From: Carmichael Ian <Ian.Carmichael@thamesvalley.pnn.police.uk>
Sent: 13 February 2020 11:06
To: Bob Neville
Cc: Planning
Subject: Planning ref: 20/00123/OUT. Cotefield Business Park Oxford Rd Bodicote OX15 4AQ.

Planning ref: 20/00123/OUT. Cotefield Business Park Oxford Rd Bodicote OX15 4AQ.

Project: Cotefield Farm	Job No: 39042
	Drawing Title: Proposed Site Plan	Drawing No: 02 rev. A
1 Water End Barns Water End Eversholt MK17 9EA t 01525 309 400 hello@madebyprosper.com madebyprosper.com	Date: Jan 2019	Client: Will Bratt
	Drawn: KD	Checked: BM
	Scale: 1:500@A1

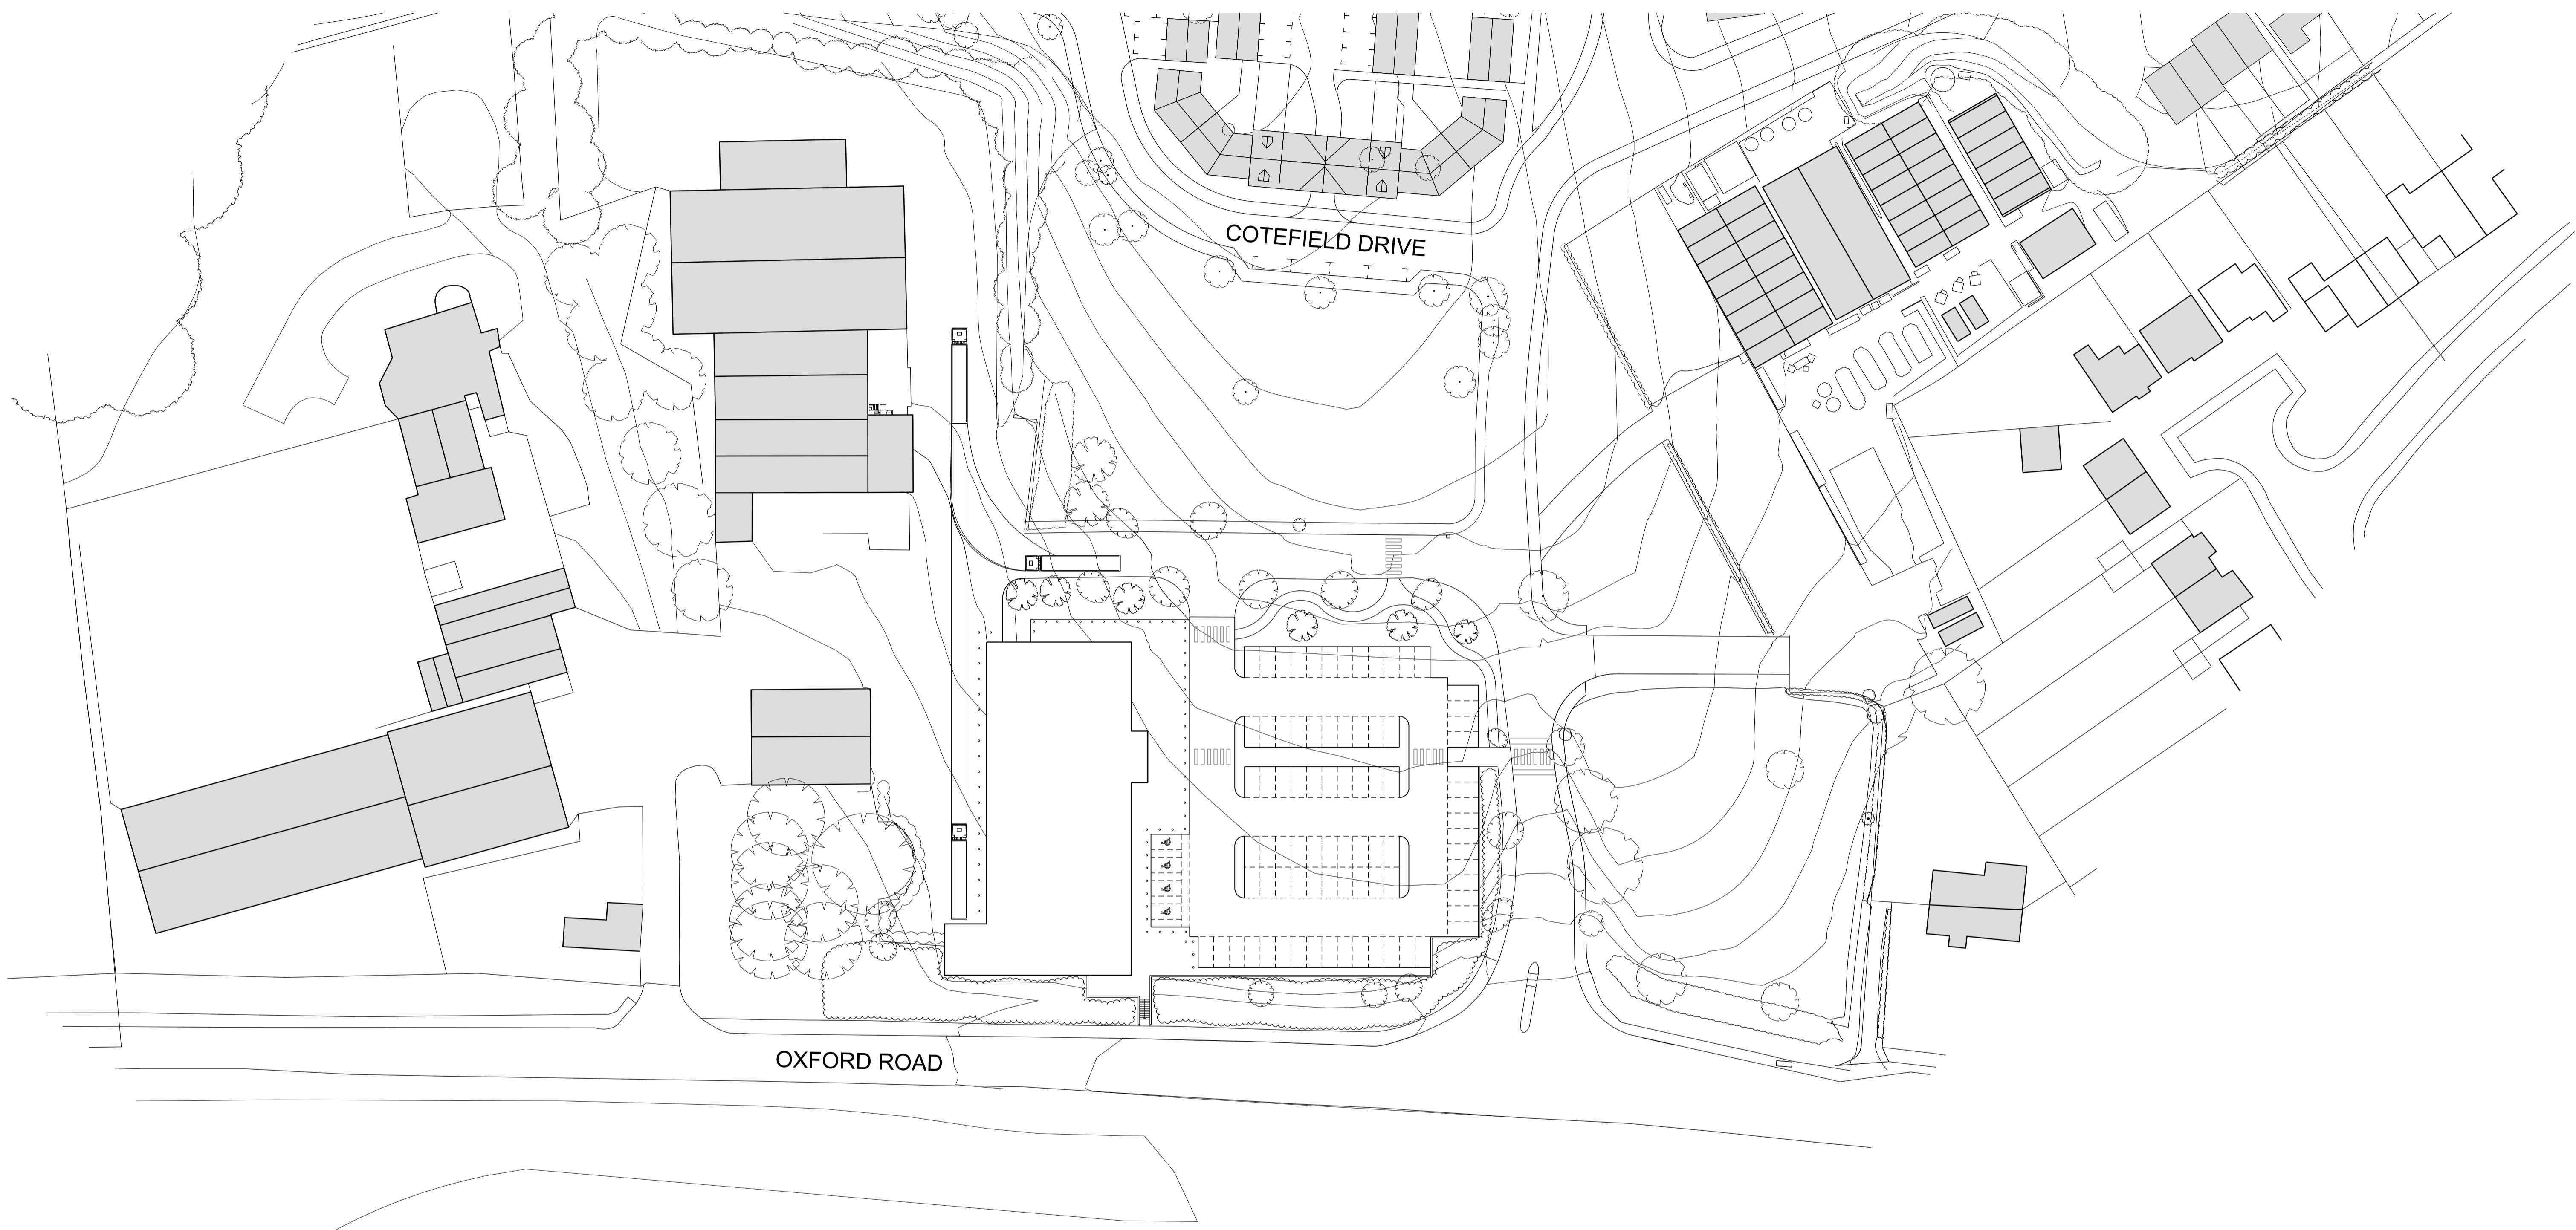
- I am concerned that the current layout appears to show that the rear service yard is unsecured with open access to the neighbouring commercial units. I recommend that these issues are addressed before any reserved matters application is made.

- I would argue that the stepped pedestrian access to Oxford Rd is not necessary and suggest it is removed from the layout. It, along with the adjacent recessed area of paving between the building and the boundary hedging on Oxford Rd, are likely to facilitate congregating and attract anti-social behaviour (ASB). If these features must remain they should be well lit, covered by CCTV and the adjacent landscaping must not hide these features from view.
